Office of
Environment
& Heritage

DOC18/94288
MP09_0180 MOD 7

OEH comments on Notification of Modification Seniors Living Housing Development, 34-36 Memorial Avenue, Kellyville (MP09_0180 MOD 7) – floodplain risk management comments

SITE OVERLAND FLOW WSUD
REQUIREMENTS FOR FLOODING
CONTROL

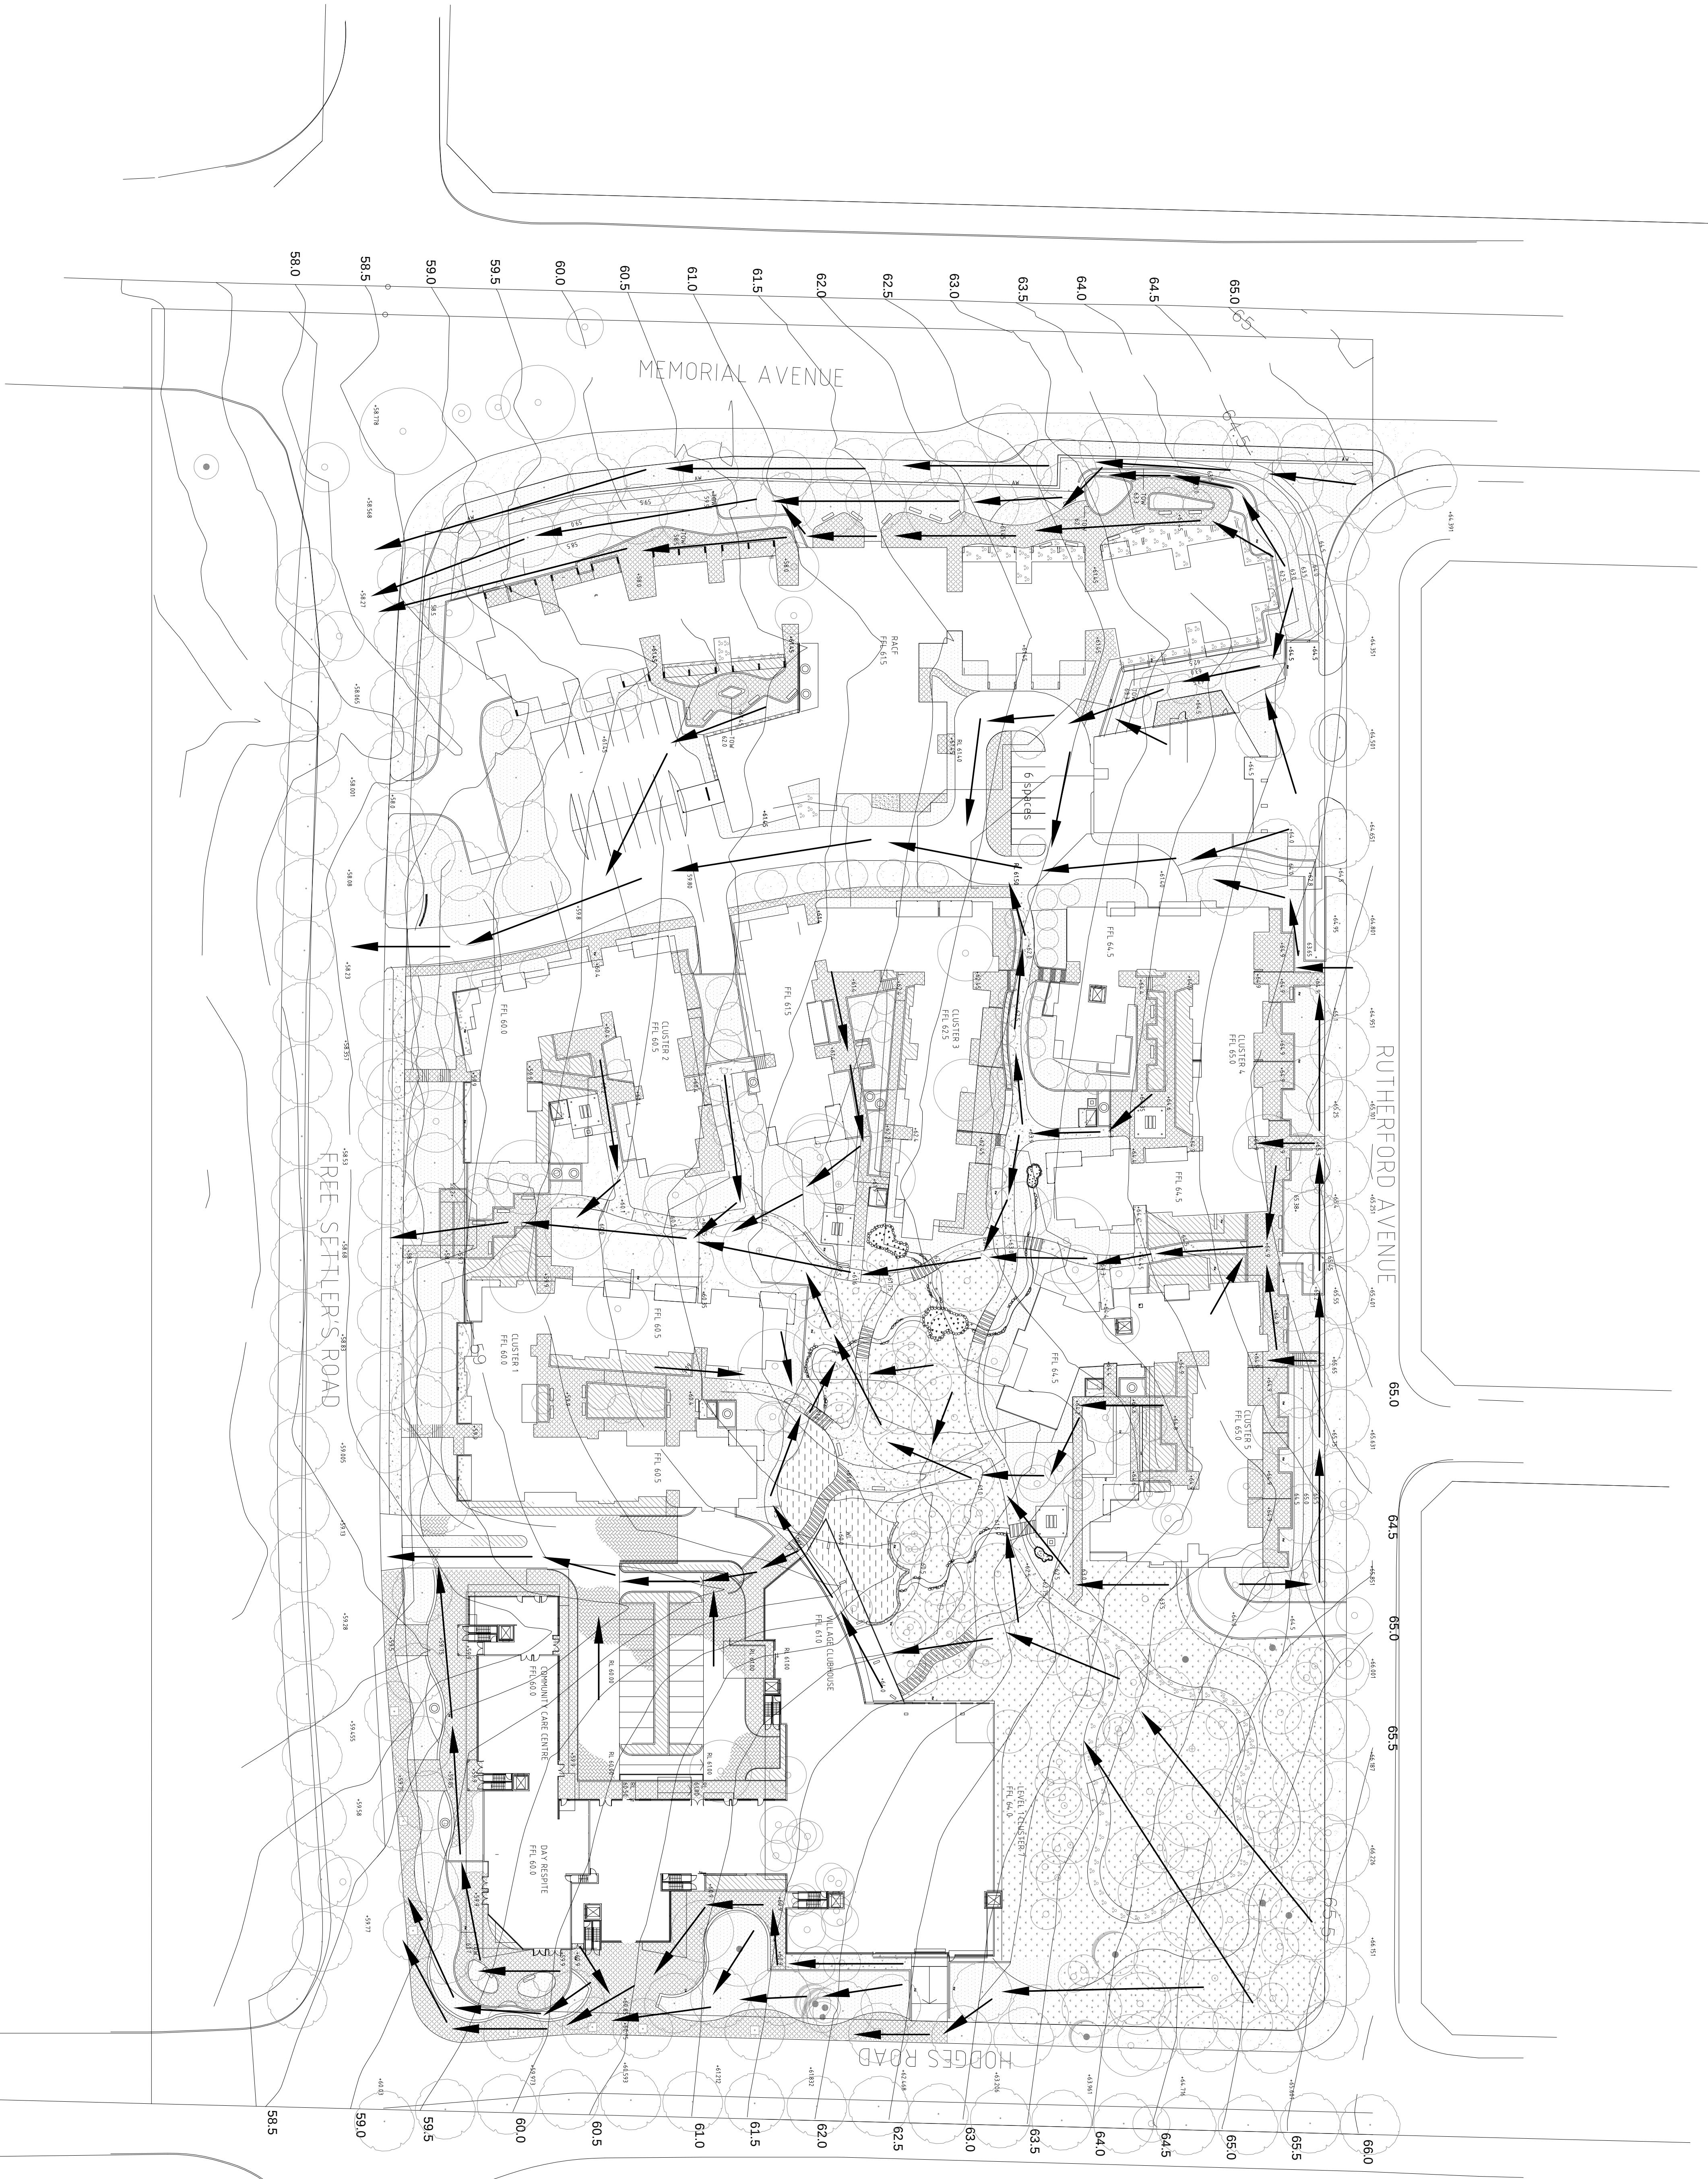
The stormwater Management Report (Wood & Grieve Engineers, December 2017) Section 3.1 indicates that major runoff for events equal to or exceeding the 1% AEP would flow overland. Section 4 states 'To ensure the localized flooding is kept to a minimal, the proposed development site has been designed to ensure all runoff is directed to the existing road infrastructure. Another critical design aspect which has been incorporated into the stormwater drainage plans are overland flow paths. Overland flow paths have been included where required to ensure that the existing flow paths are maintained and unobstructed.' However, the report does not provide any details as to the overland flow path characteristics i.e. volume, depth, extent, velocity and duration for the full range of events (i.e. up to the PMF).

OEH notes that the proponent in Section 4 states '...the site is not subject to flooding and is not restricted by existing drainage capacity'. However, this information should be based on over-land flow (OLF) assessment. Under the NSW Government's Flood Prone Land Policy, the principles of the Floodplain Development Manual (2005) applies to lands affected by overland flow. Therefore, details on OLF should be included in the report for the proposed site and adjacent areas for the full range of events up to the PMF.

OEH understands that Council has developed The Hills Urban Overland Flow Study and recommends that this study is utilised to provide details on OLF within the whole site for the developed scenario.
